**Consultation Response from KC,
Lead Local Flood Authority**

2026/91969 land off, Fenay Lane, Almondbury, Huddersfield, HD5 8UJ

Erection of 6 dwellings, with associated access, landscaping, infrastructure and works

- 26-255-D01, Drainage Plan, Rev P01 dated 23/06/2026
- 26-255, Drainage Strategy, Rev P01 dated 06/07/2026

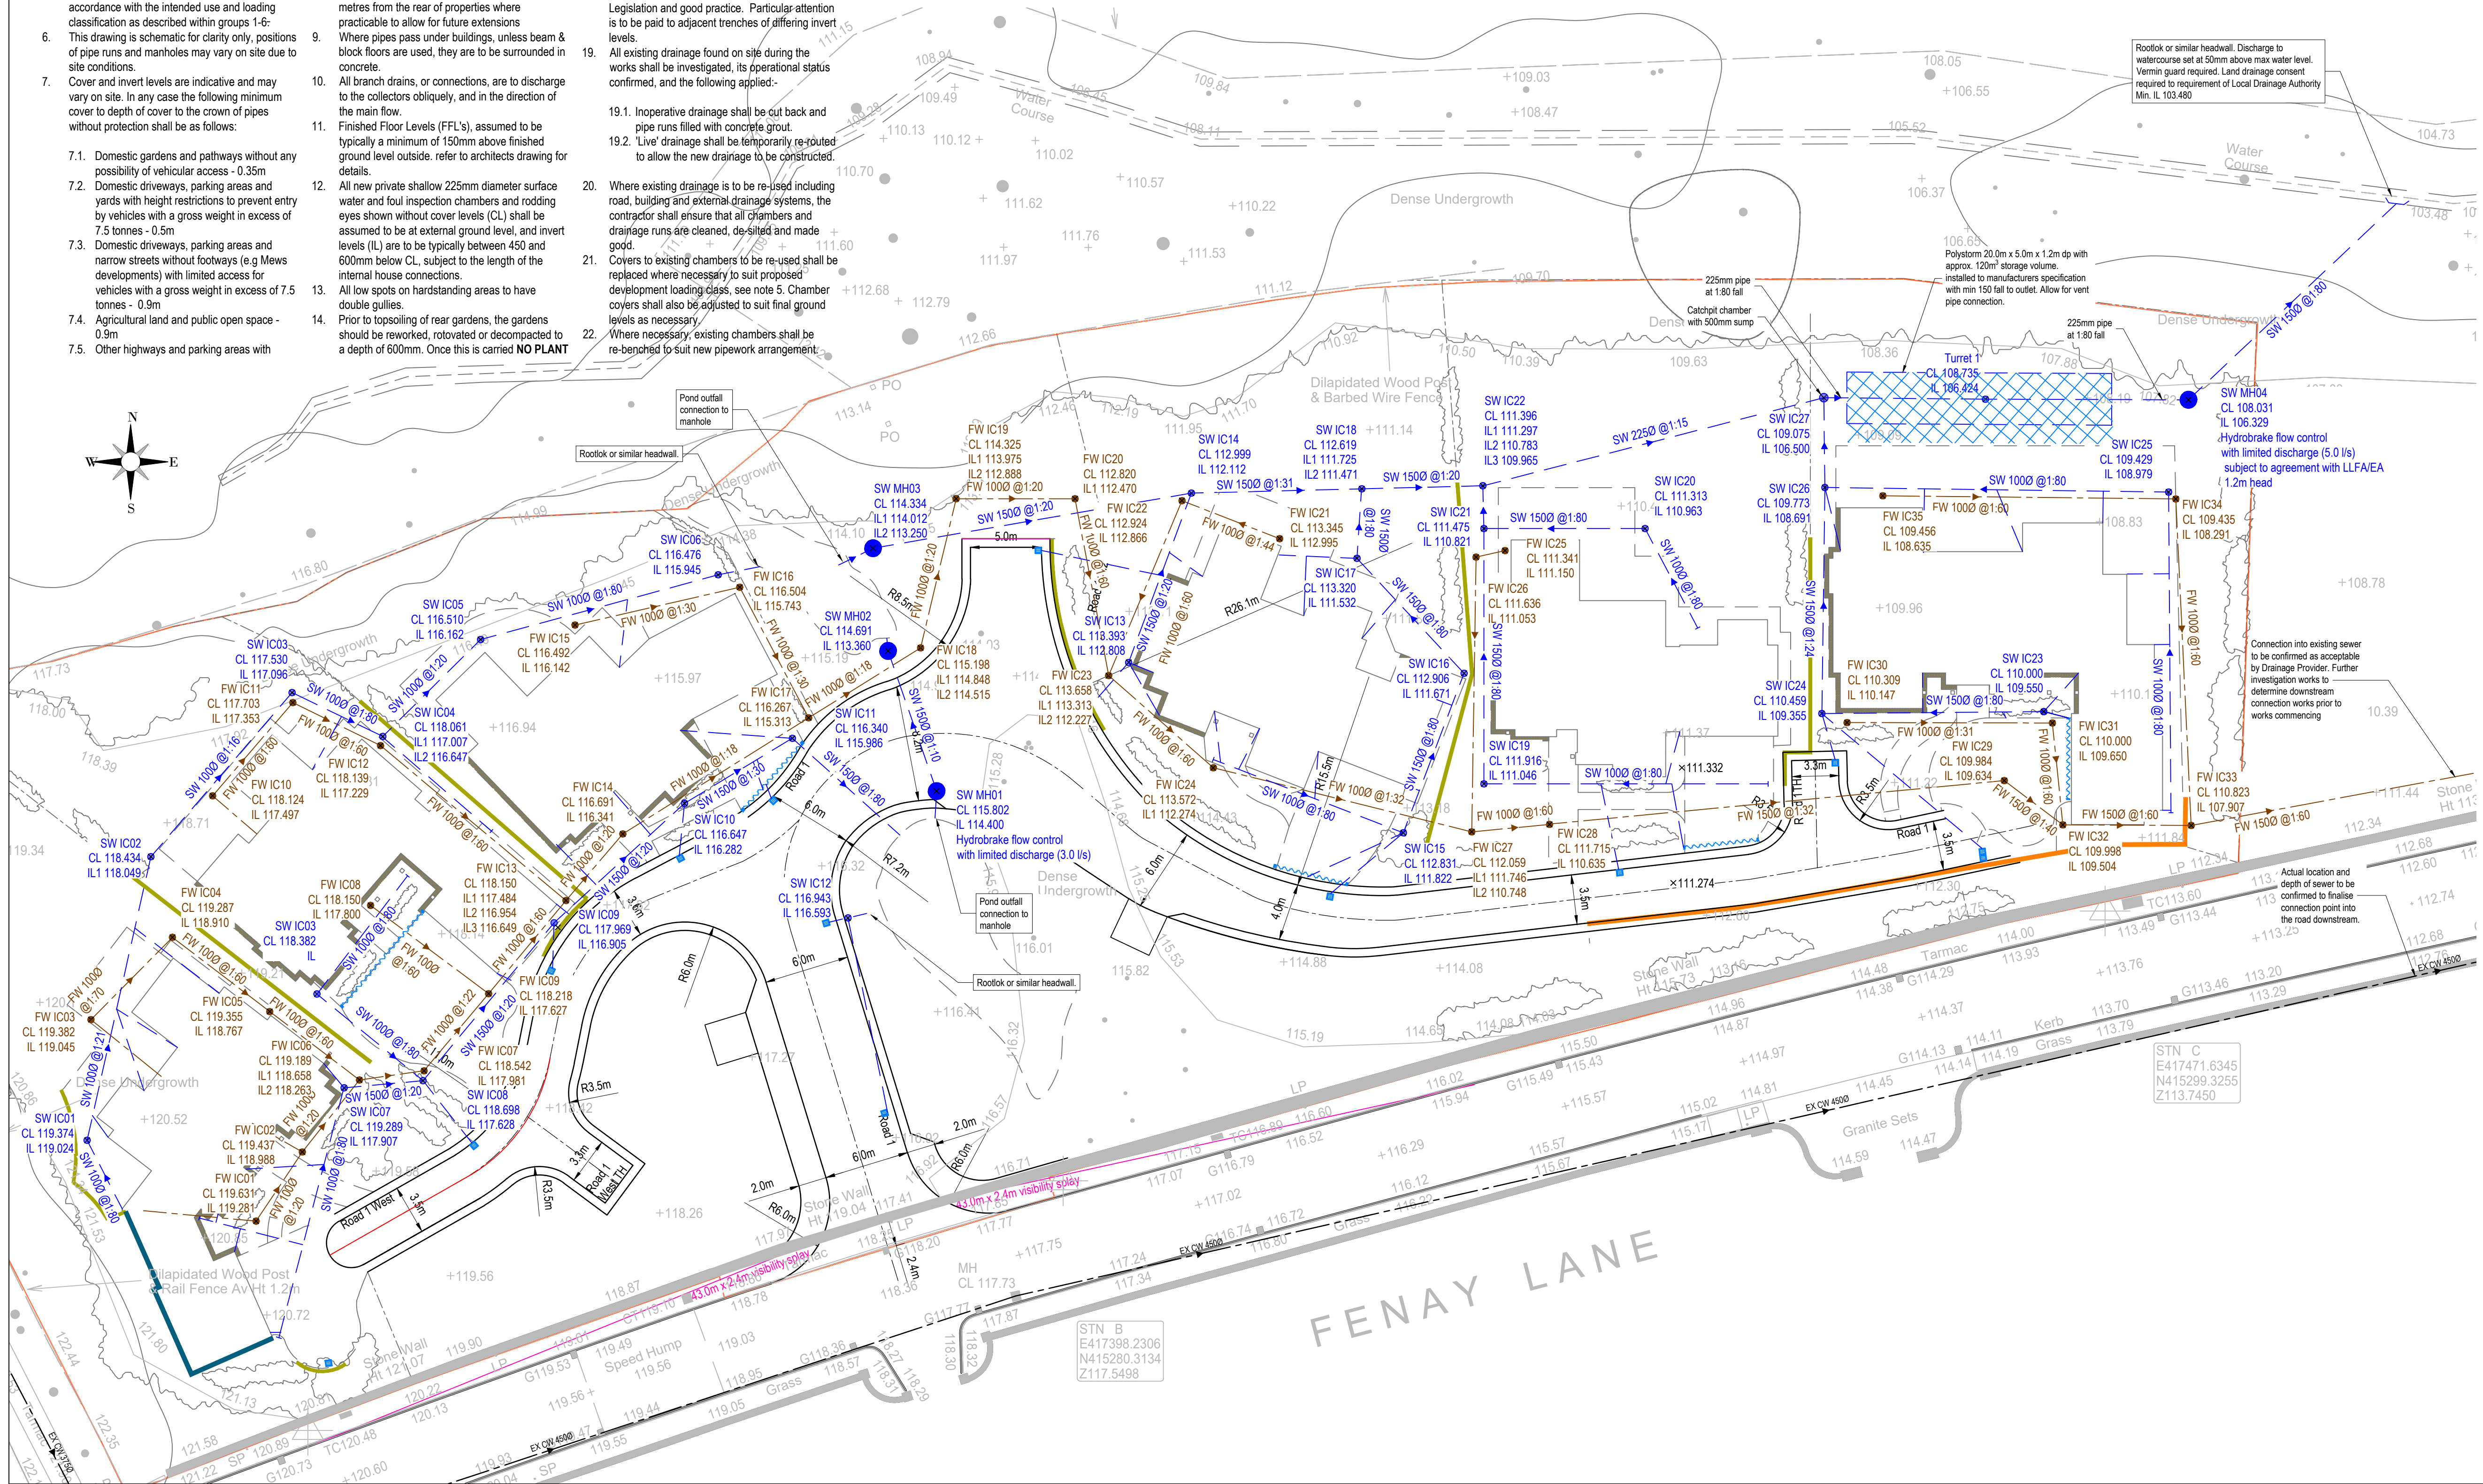
- It is recommended that a self-cleansing channel or perforated pipe is used at the base of the tank to allow rainwater run-off during low flow events to pass through the tank between the external upstream and downstream MHs, thereby reducing the risk of siltation within the tank.

- Hydraulic calculations will need to be submitted to the LLFA showing that the attenuation storage is sufficient for the critical design storm.
- The attenuation tank and flow control chamber appear to be within the private curtilage of the last housing plot on the eastern side of the site. This would make it difficult to undertake future inspections and maintenance activities if, for instance, this area is fenced off or sheds, extensions, etc. are built over the tank/flow control chamber.

- Without adequate access to the attenuation tank and flow control chamber from non-private areas, it is unlikely that they will be adopted by Yorkshire Water. Therefore details of the organisation who will be responsible for the maintenance for the life of the development should be submitted to the LLFA.
